**CITY OF PORTLAND, MAINE
DEVELOPMENT REVIEW APPLICATION
PLANNING DEPARTMENT PROCESSING FORM
DRC Copy**

2004-0022

95 Cove Side Dr.

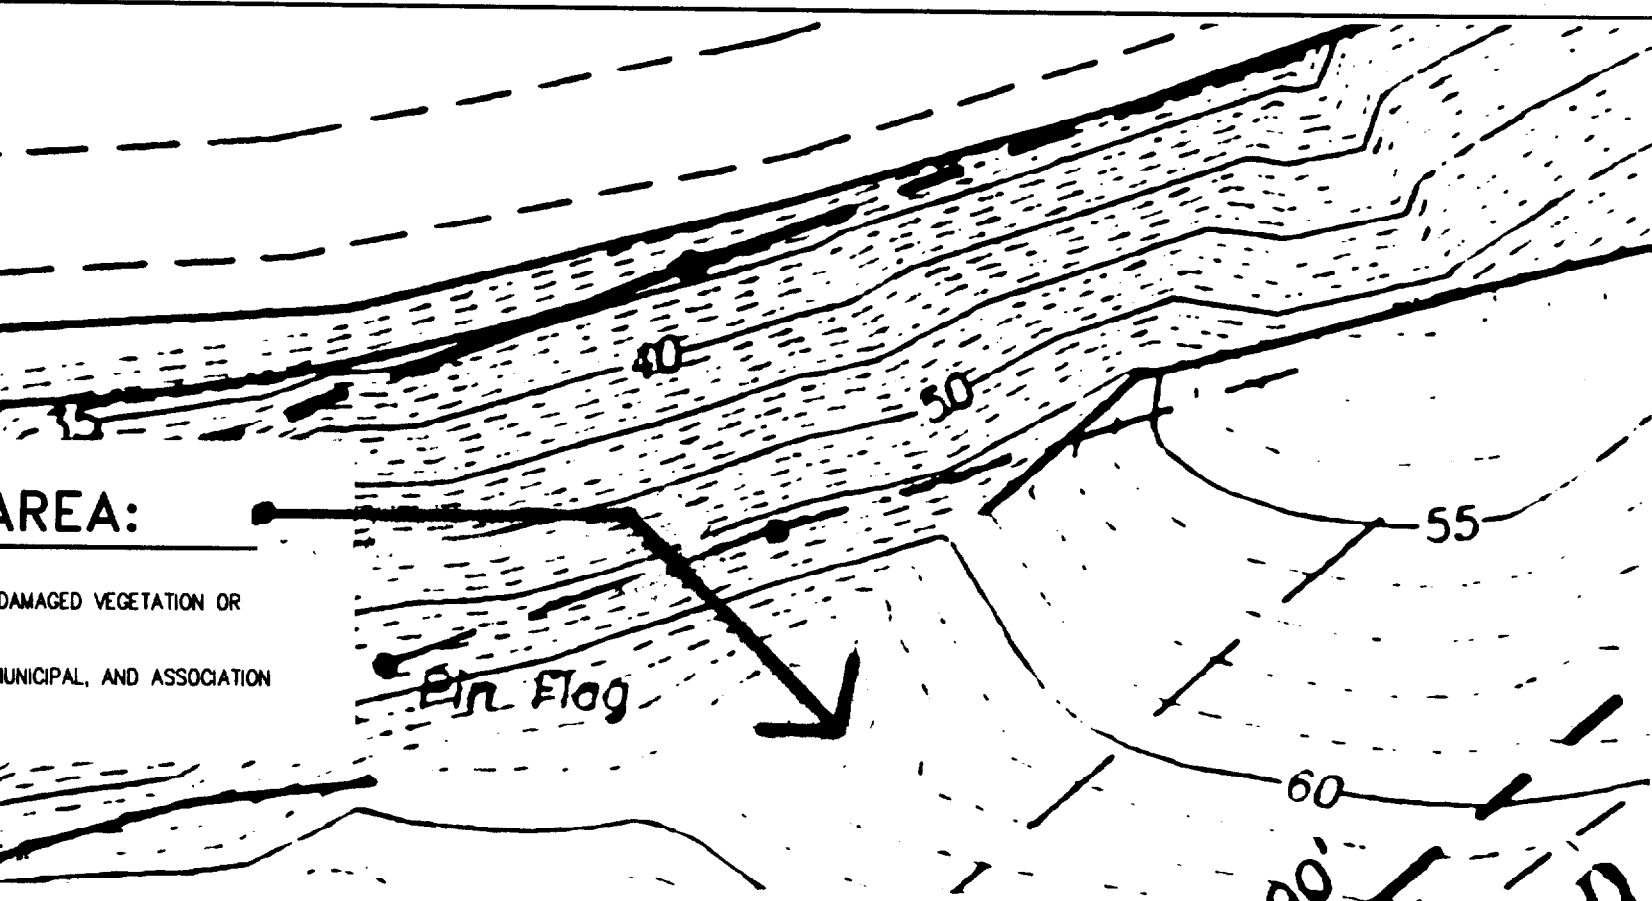
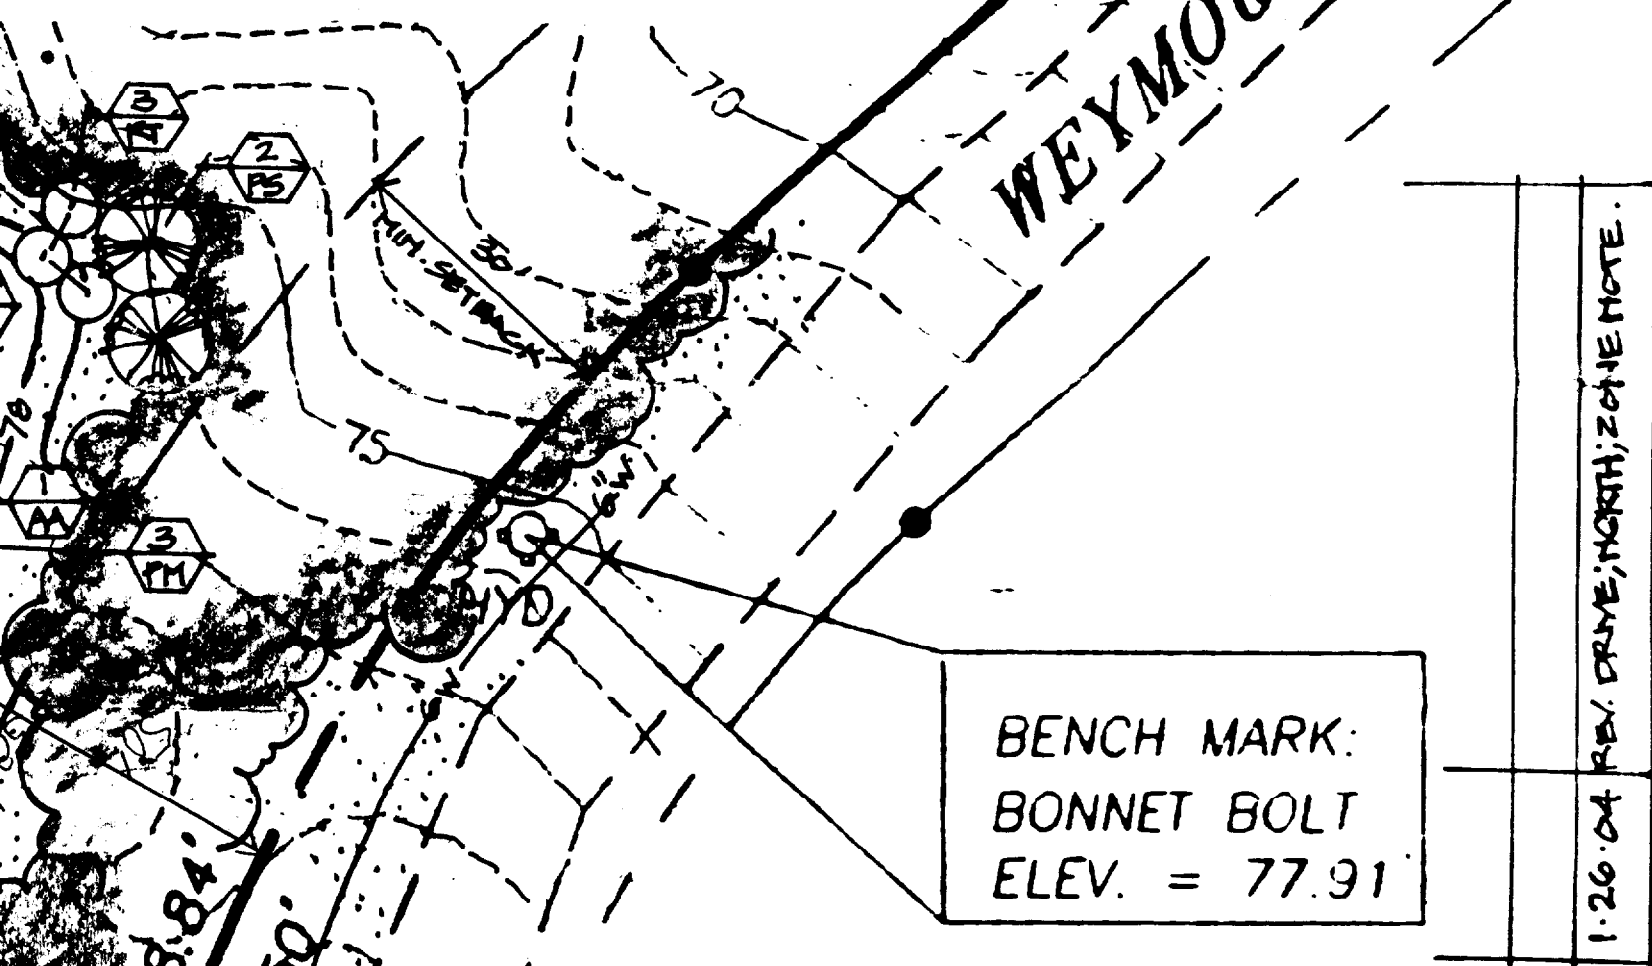
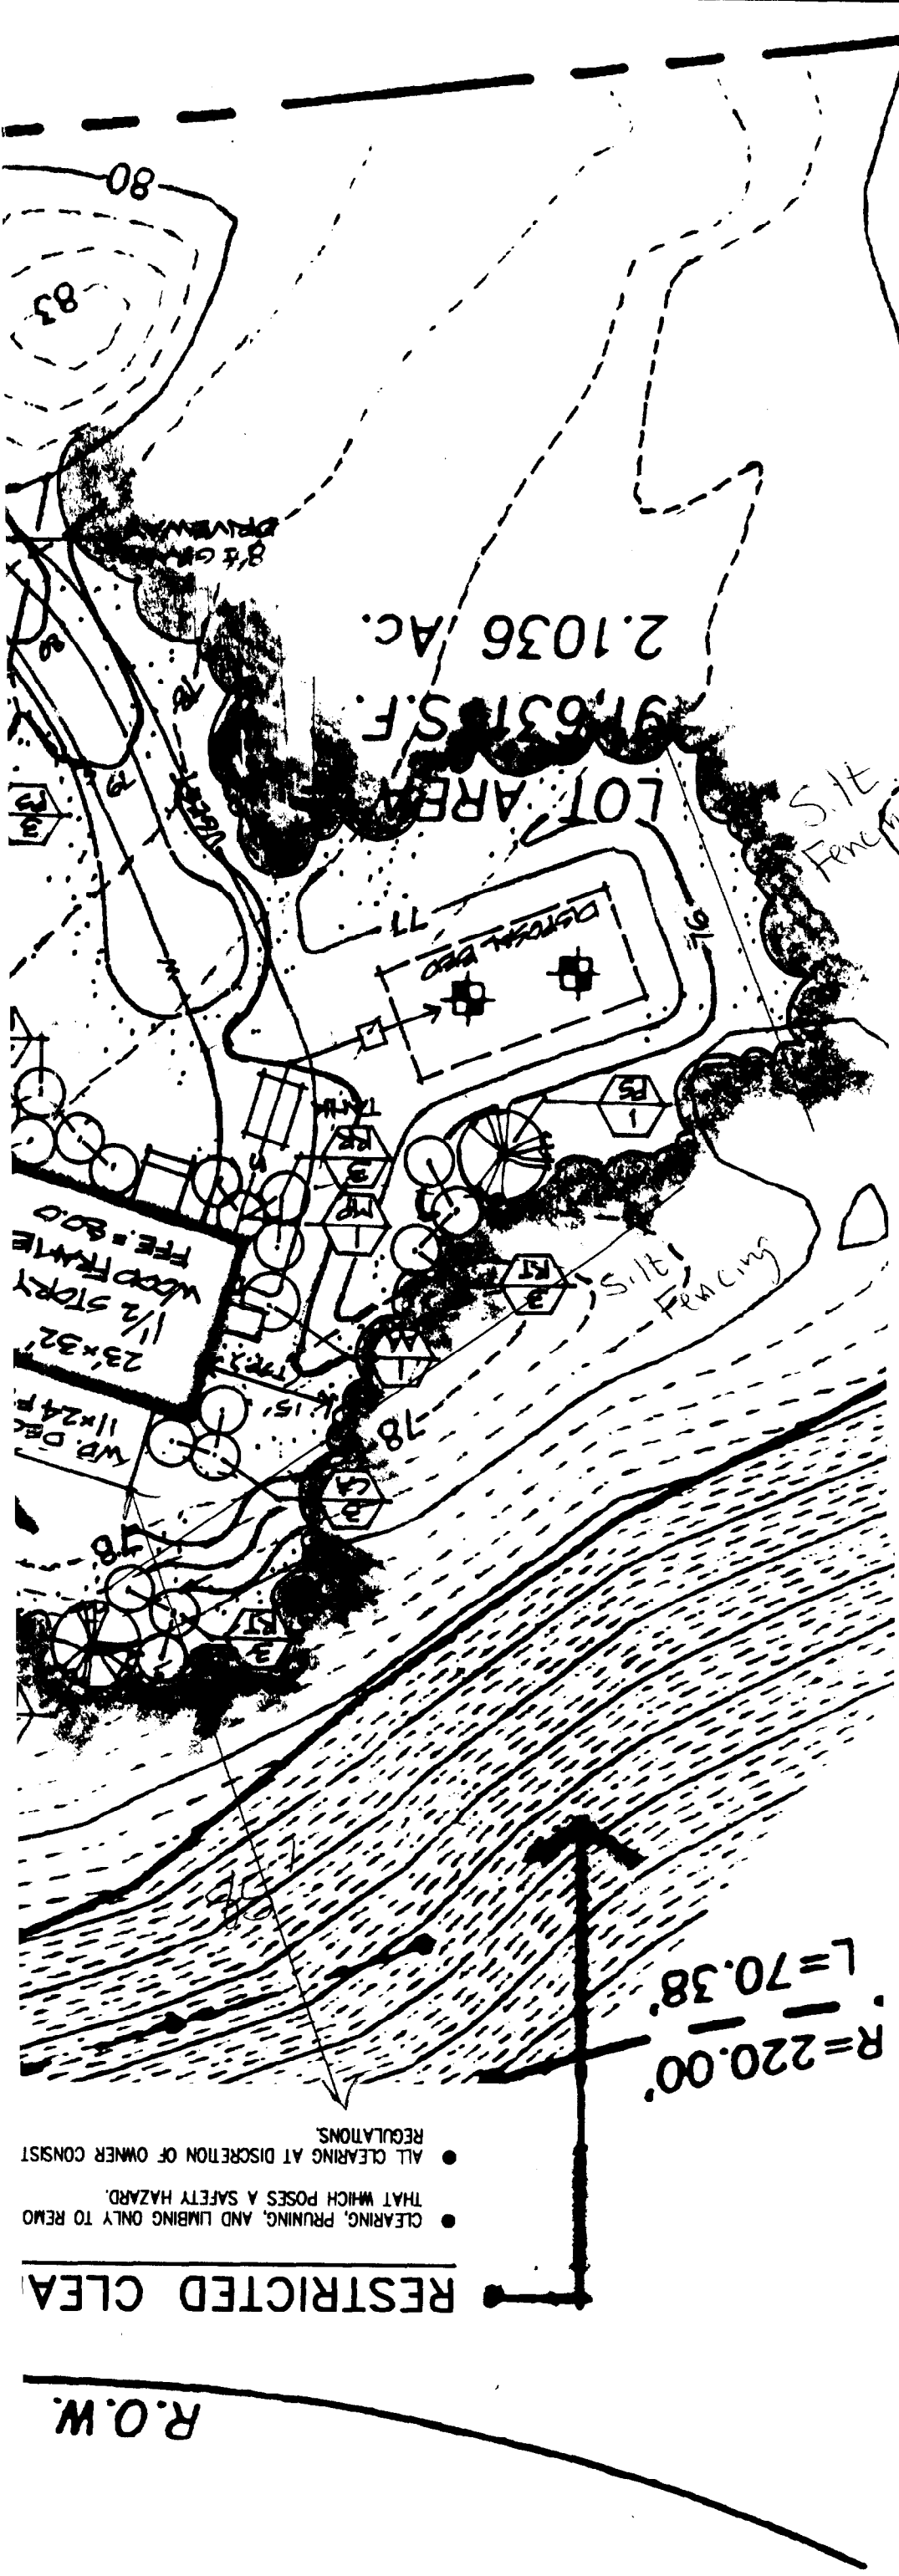
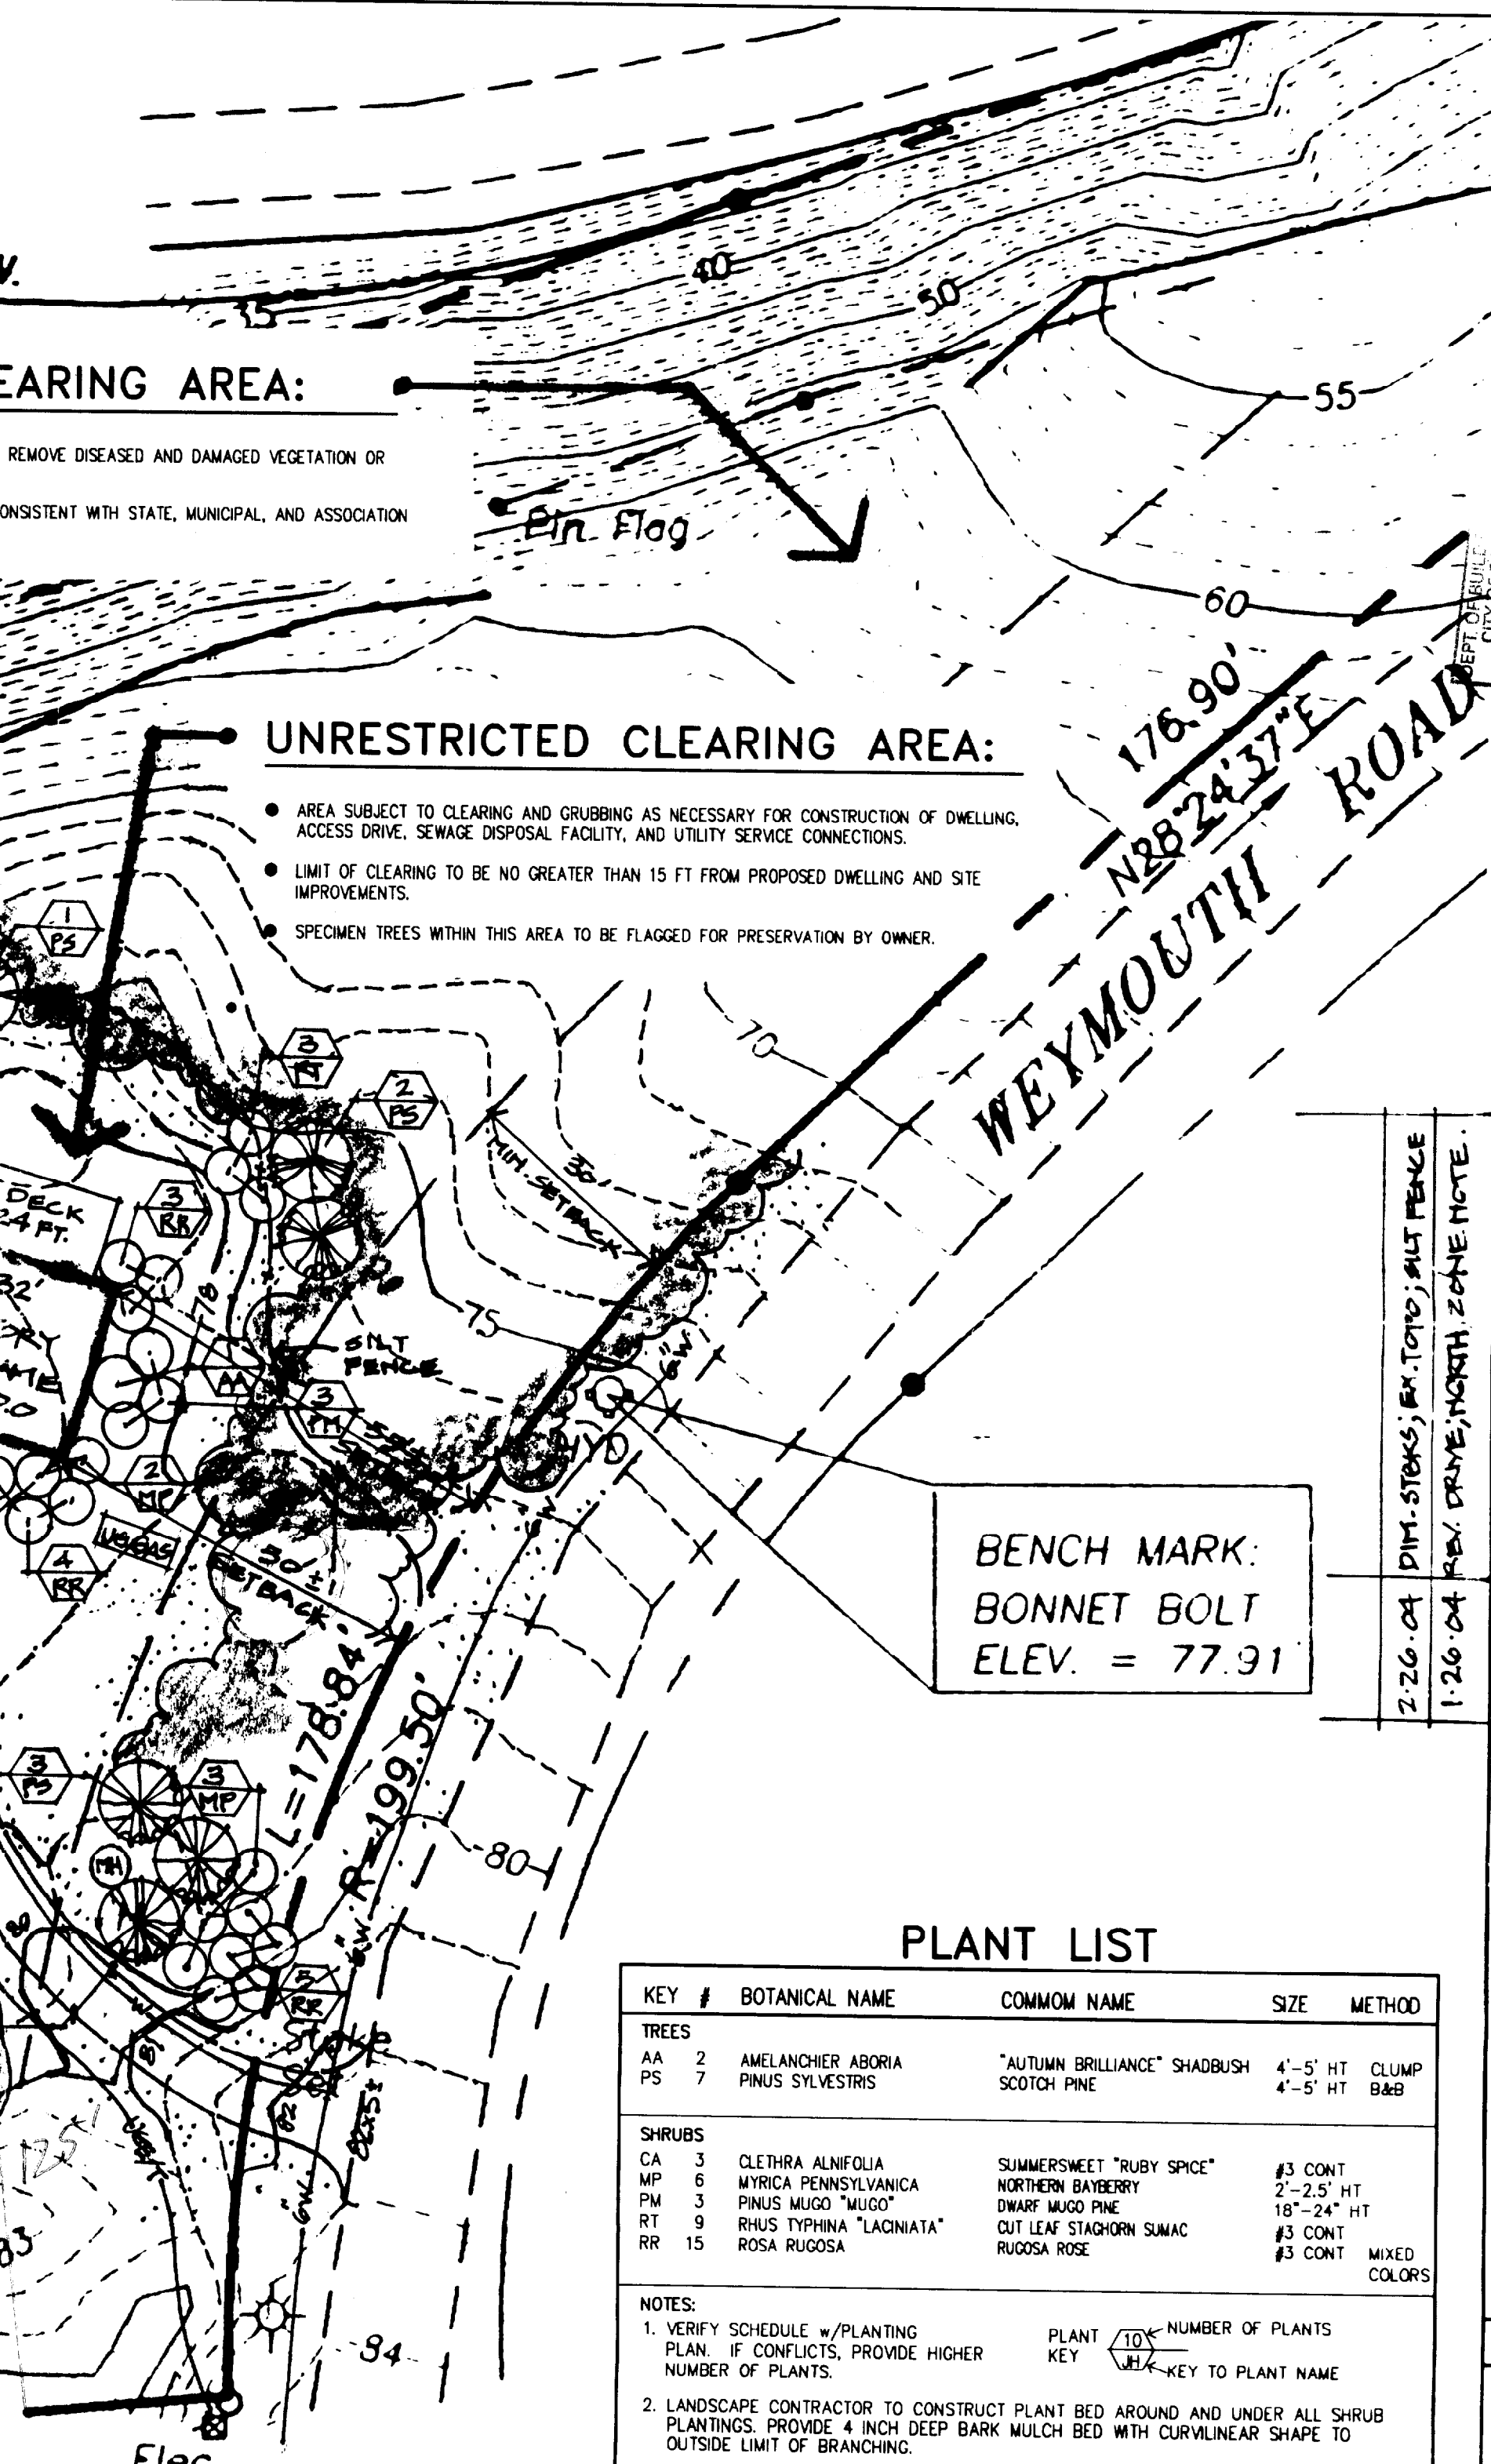
- 1 Silt Fence installation shall remain outside of the restrictive clearing area.
- 2 Your new street address is now #36 Weymouth Road, the number must be displayed on the street frontage of your house prior to issuance of a Certificate of Occupancy.
- 3 A street opening permit(s) is required for your site. Please contact Carol Merritt ay 874-8300, ext. 8822. (Only excavators licensed by the City of Portland are eligible.)
- 4 The Development Review Coordinator reserves the right to require additional lot grading or other drainage improvements as necessary due to field conditions.
- 5 All Site Work will conform to the City of Portland ordinance on Shoreland Regulations (Division 26).
